DRB-1002723

DEVELOPMENT REVIEW BOARD--SPEED MEMO

**DRB CASE NO/PROJECT NO: 1002723**

Re: Sketch Plat Review and Comment  
Alvarado Elementary School

**SKETCH PLAT
TRACT A, ALVARADO ELEMENTARY SCHOOL**

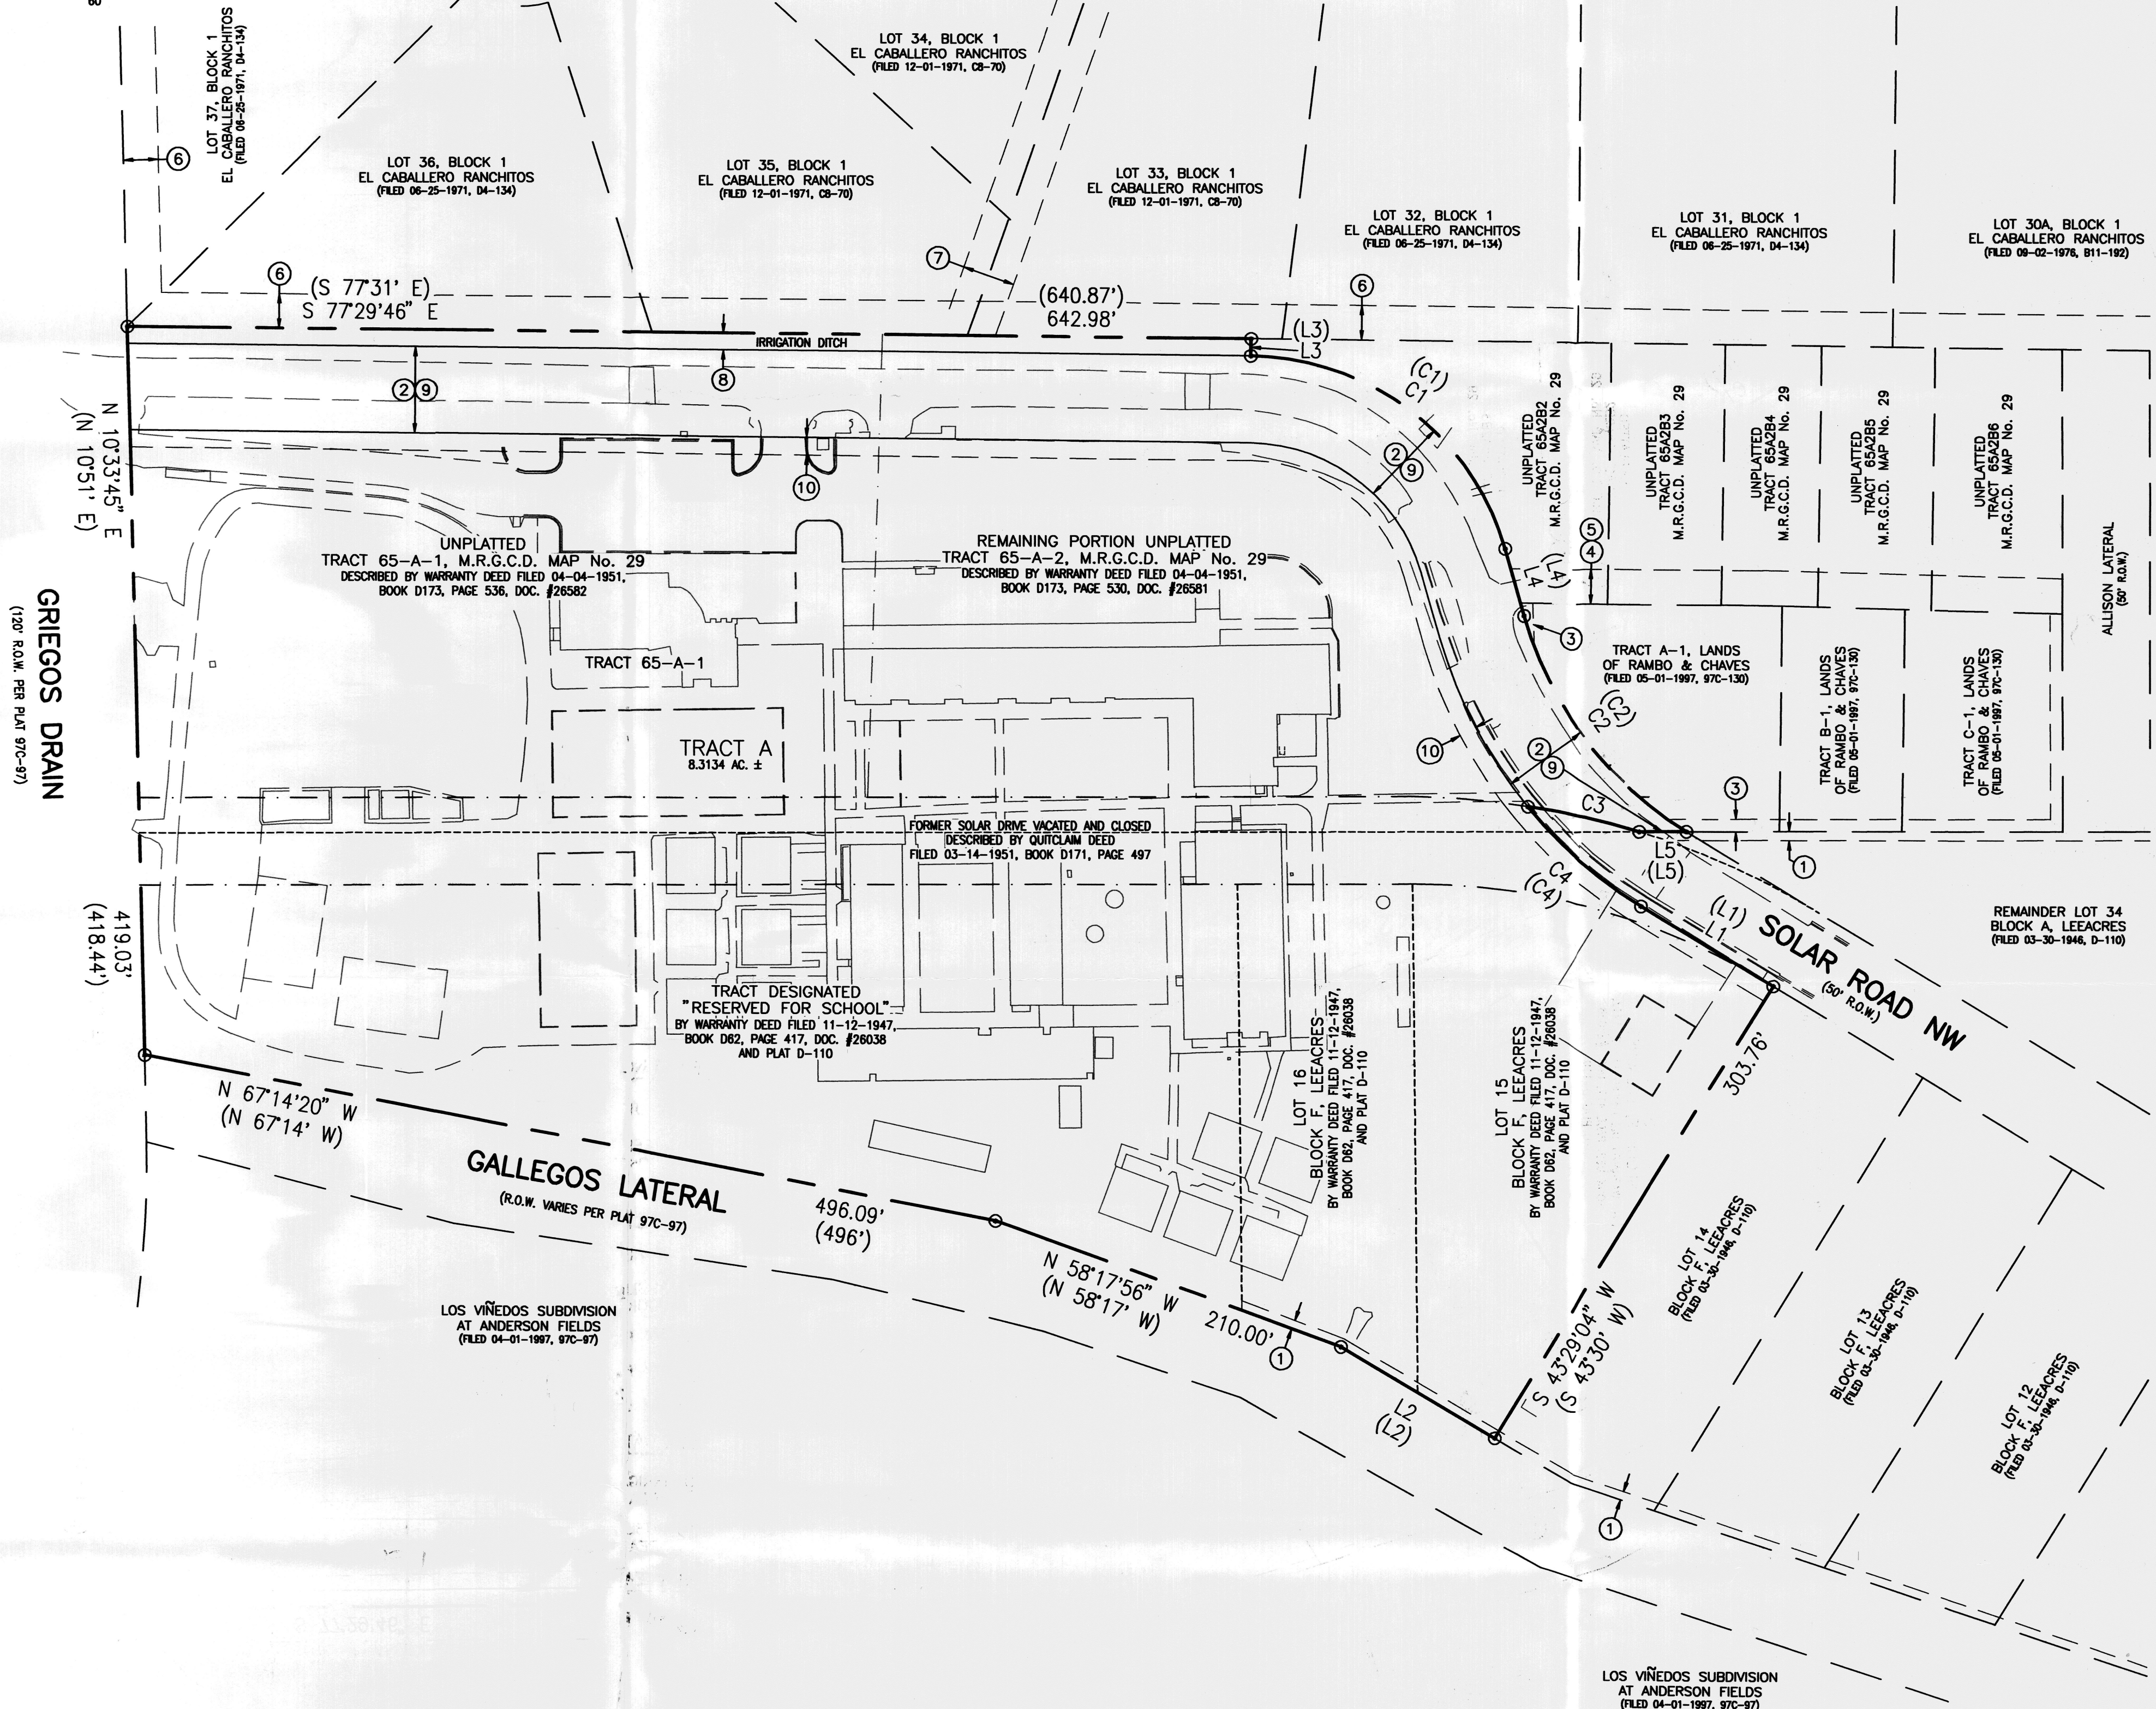
No.	Comment
<input type="checkbox"/>	When a site dedicates right-of-way or is adjacent to a street that is substandard, the street should be brought up to standards.

MRGCD must sign plat.
